From: David Margolis-Pineo
To: Jean Fraser
CC: Barbara Barhydt; Philip DiPierro
Date: 2/24/2014 3:02 PM
Subject: Munjoy Heights Development

I have reviewed the most recent set of plans for Munjoy Heights and find that the review comments submitted by Public Services have been addressed.

BRICK DRIVEWAY APRON WITH BITUMINOUS BASE DETAIL
NOT TO SCALE

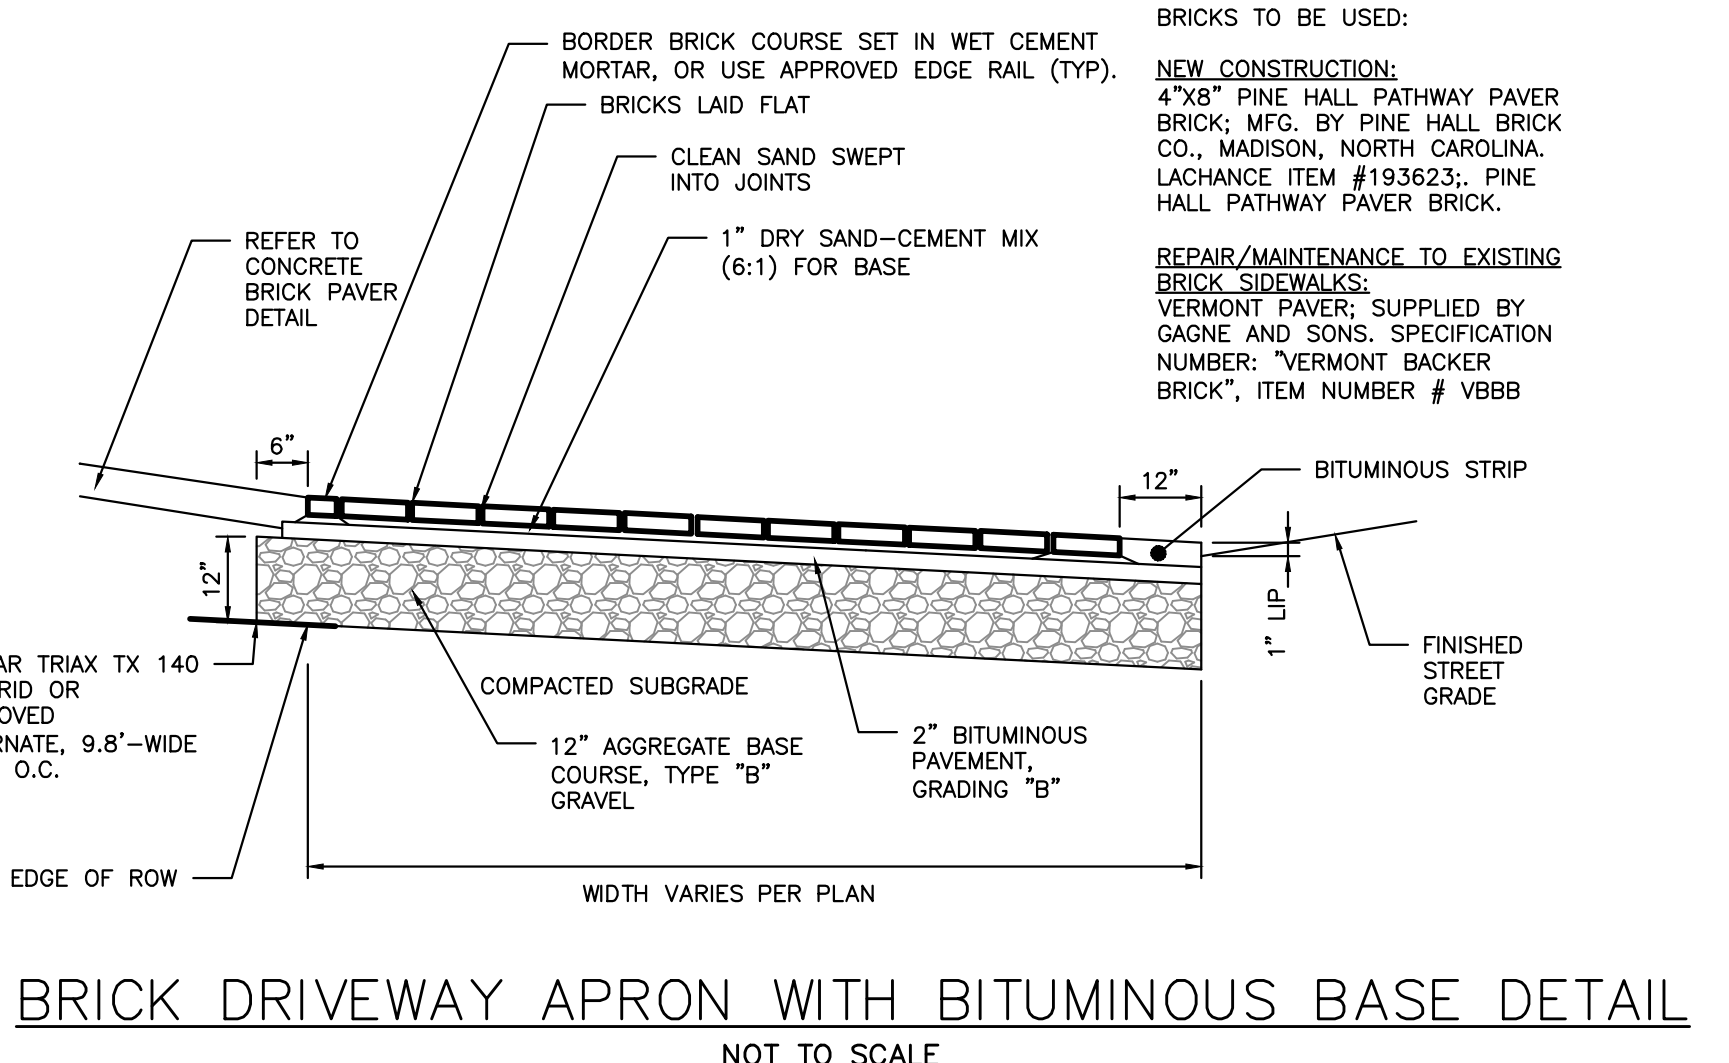
It is noted that the applicant is requesting to install a brick driveway apron which does not meet the City's standards for this area of the City and such a request would required a waiver by the City Council. This department is supportive of a waiver request.
